**\*PRE-HEARING STAFF ANALYSIS\***

**Rezoning Petition No. 2008-33**

**Location:** Approximately 2.1 acres west of Park Road between Heather Lane and Drexel Place

**Request:** R-4, single family residential, and O-2, office district, to MUDD(CD), conditional mixed-use development district

**PRELIMINARY
SITE PLAN**

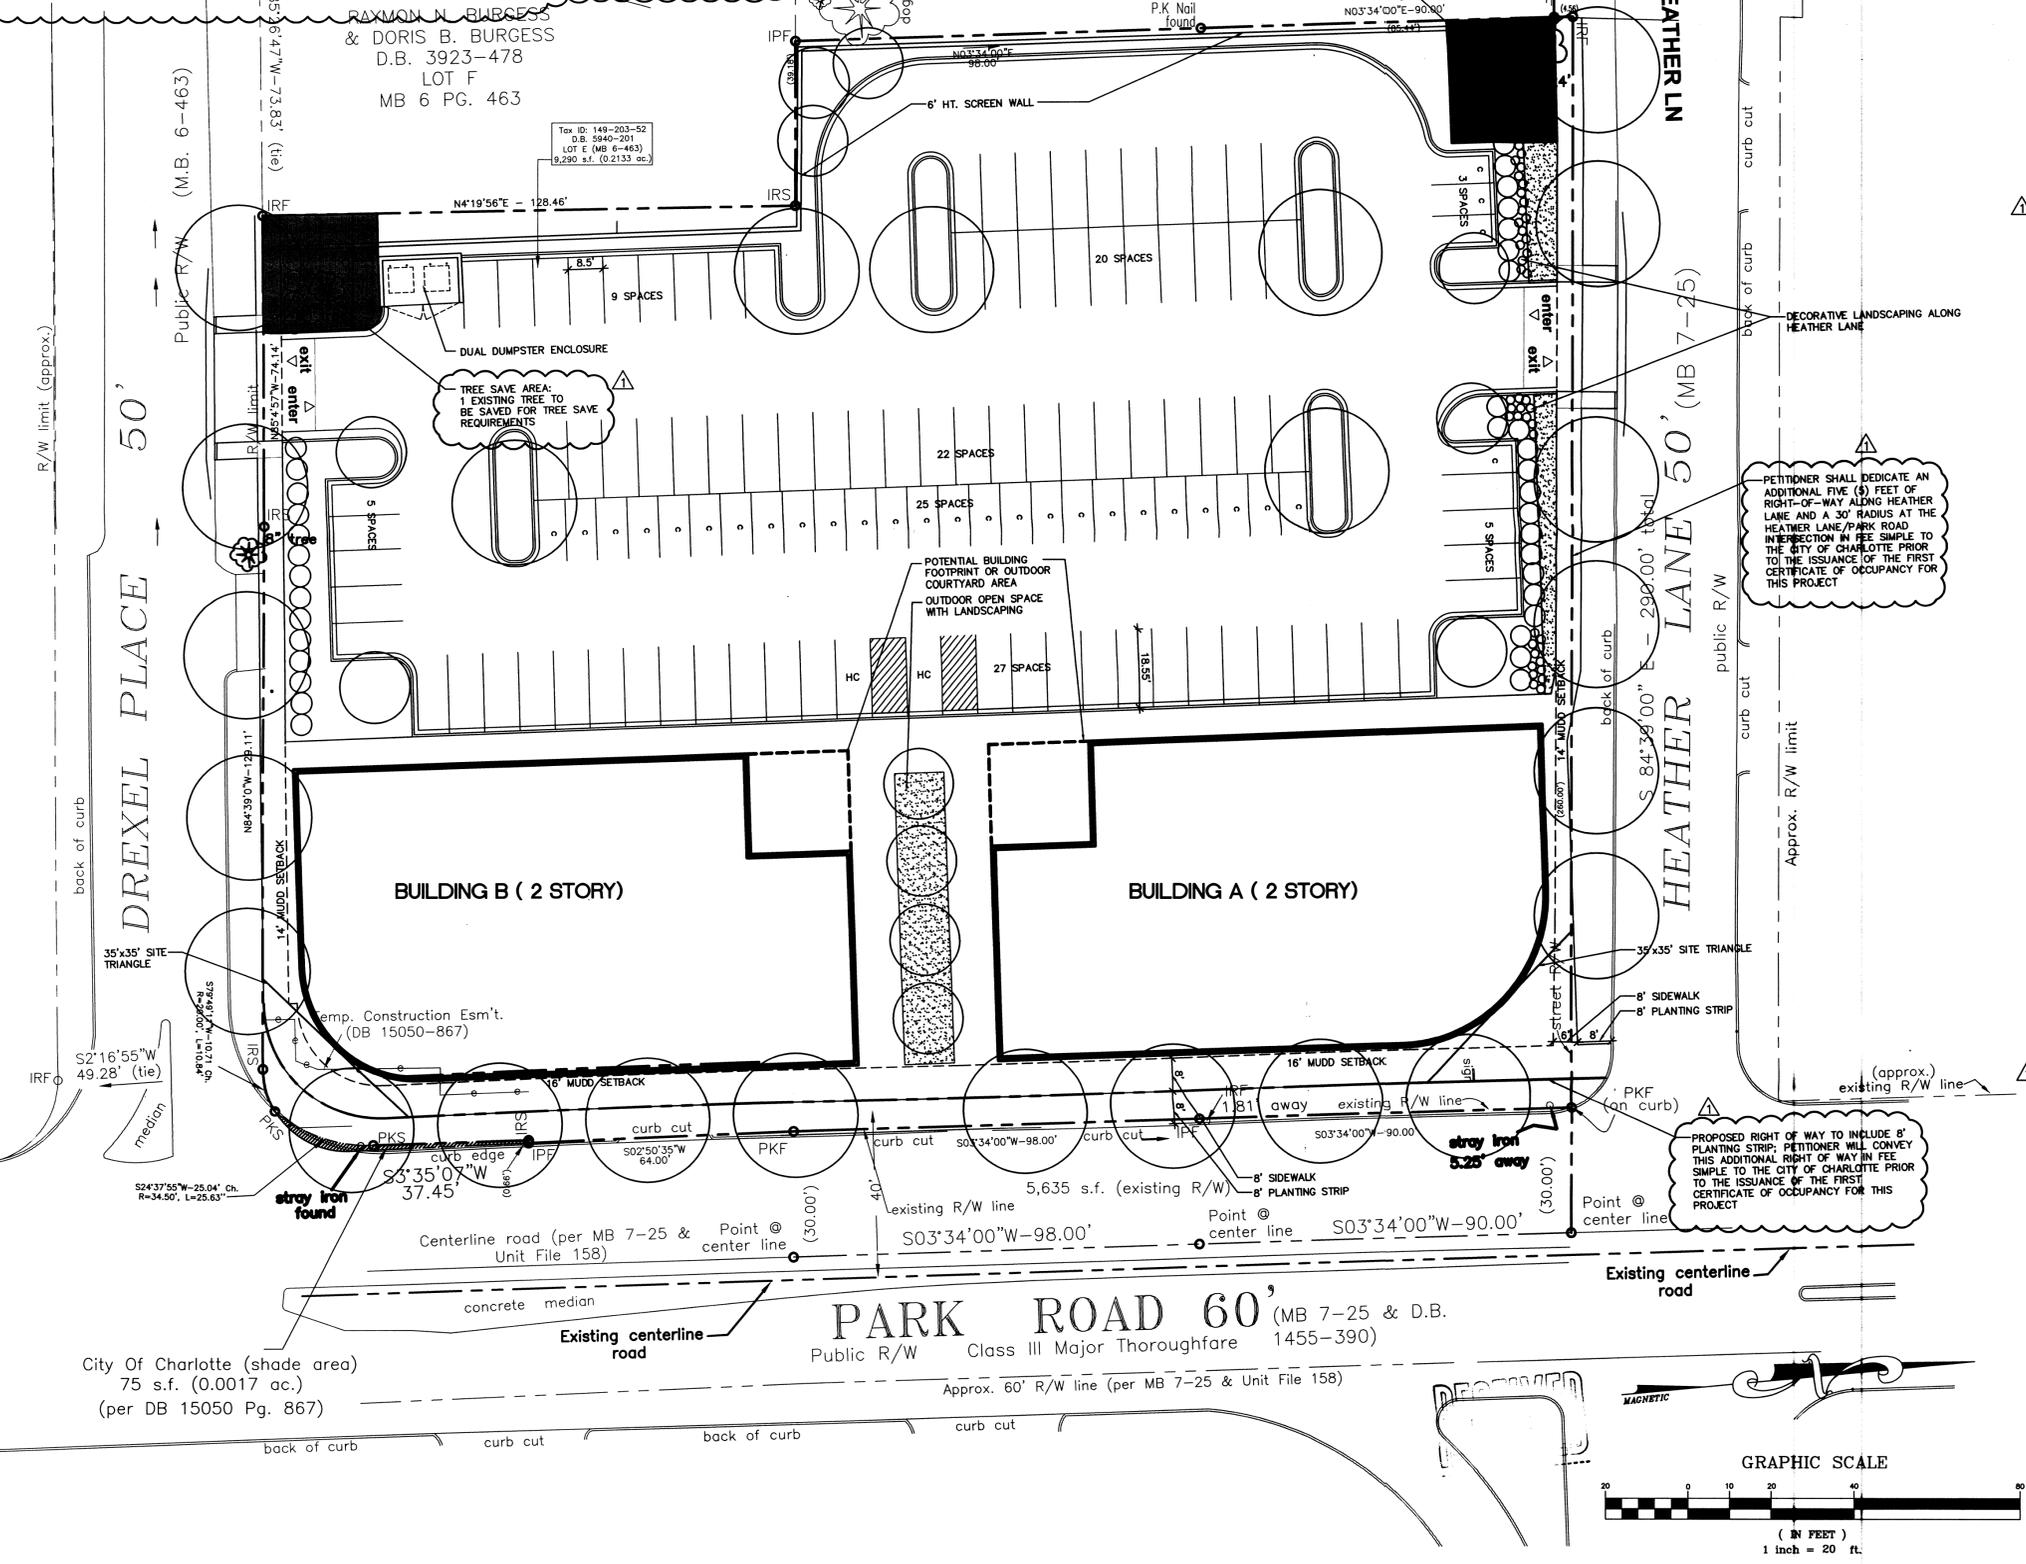
**Storm Water.** While the revised site plan commits to water quality and quantity improvements, Storm Water Services is seeking removal of a potentially conflicting note and some additional language.

**Site plan.** The site plan accompanying this petition contains the following deficiencies:

- A note needs to be added that the site plan will meet the natural area requirements of the recently adopted Post-Construction Ordinance.
- A detail of the six-foot screening wall is needed. If wooden, it should include brick columns no more than 40 feet apart.

- The width of the sidewalk on Heather Lane is shown as both six and eight feet in width. This needs to be clarified.
- The MUDD district parking standard needs to be removed from the site plan to avoid confusion with the parking standards established elsewhere on the plan.

- A note needs to be added that new utility structures cannot be placed between the building and Park Road.
- A note needs to be added that clear glass is needed on the ground floor and that all tenant spaces must have opening doors from the Park Road side or the courtyard between the buildings. Those doors must not swing onto the sidewalk space.

- A low wall of 30-36 inches is needed to screen the parking along Heather Lane.
- The modifications requested by Storm Water Services need to be added to the site plan.
